Our ref: HA/2015/117322/02-L01
Your ref: LU/228/15/PL
Date: 24 September 2015

**AMENDED PLAN: CONVERSION OF GROUND & FIRST FLOOR AT THE REAR
INTO TWO 2 BEDROOM FLATS 10 ST CATHERINES ROAD LITTLEHAMPTON
BN17 5HS**

Environment Agency Position

NEW GROUND FLOOR PLAN AND FLAT 1

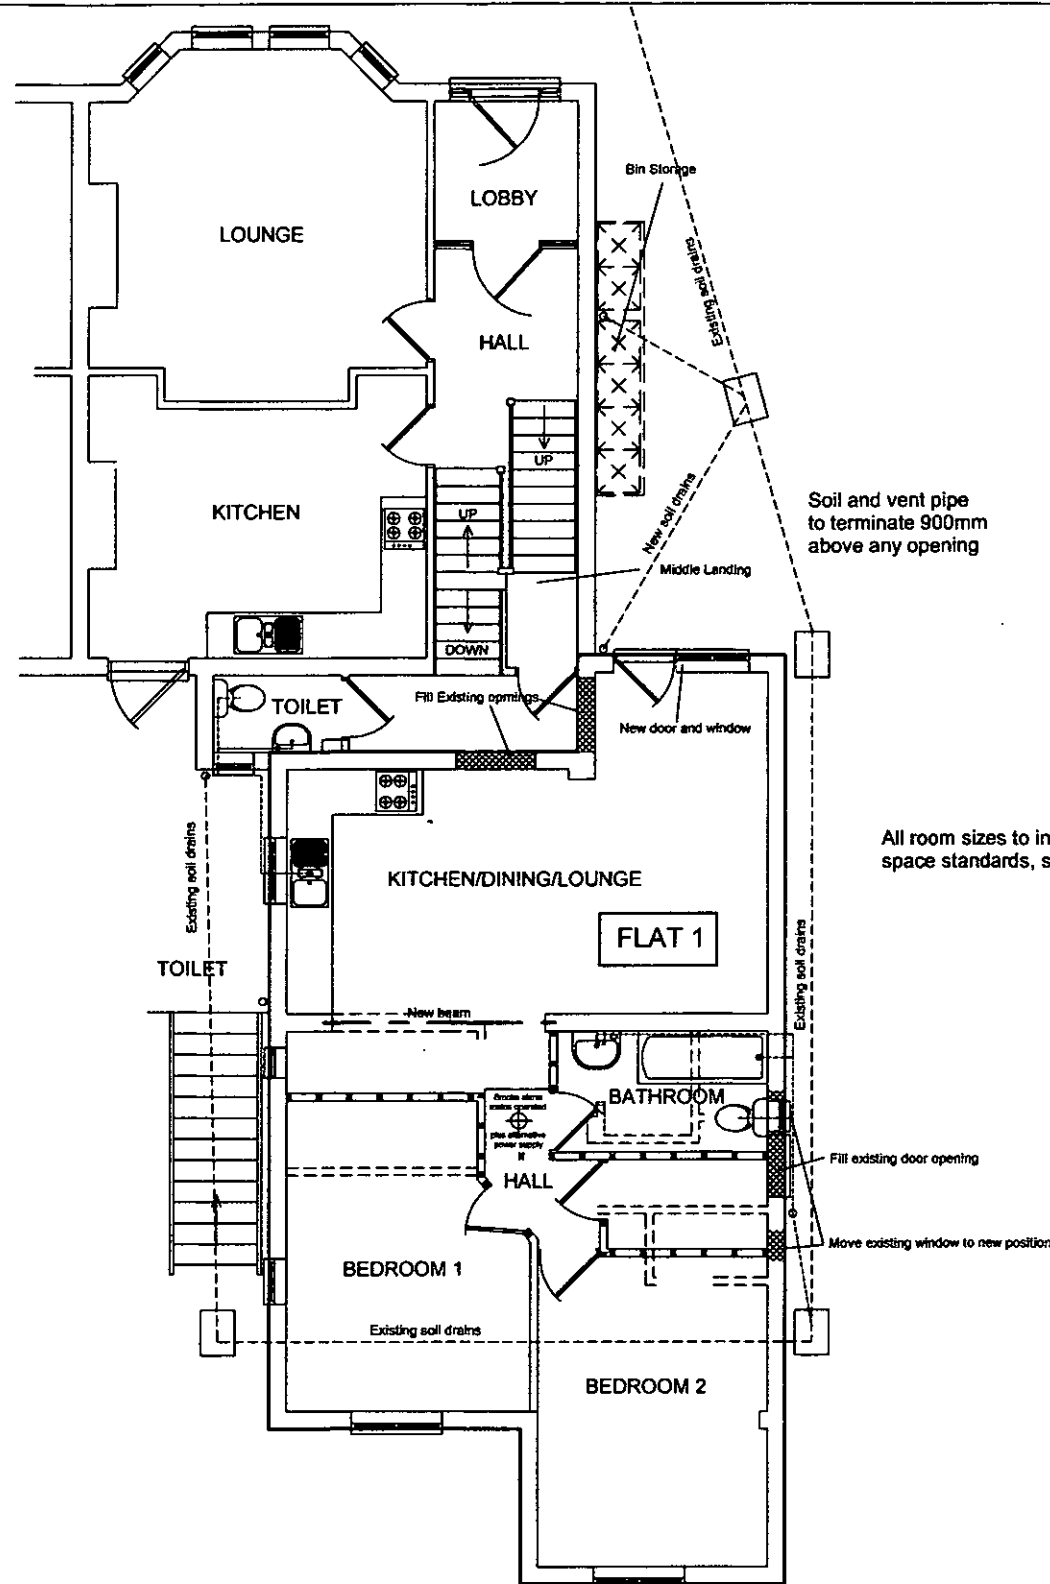
The application site is shown to be within flood zone 3, a high flood risk area in accordance with NPPF. There is the potential for flood depths of over 1 meter therefore we would consider that sleeping accommodation on the ground floor with no access to the first floor may pose an unacceptable risk to occupants in accordance with Table 13.1 of FD2320/TR2.
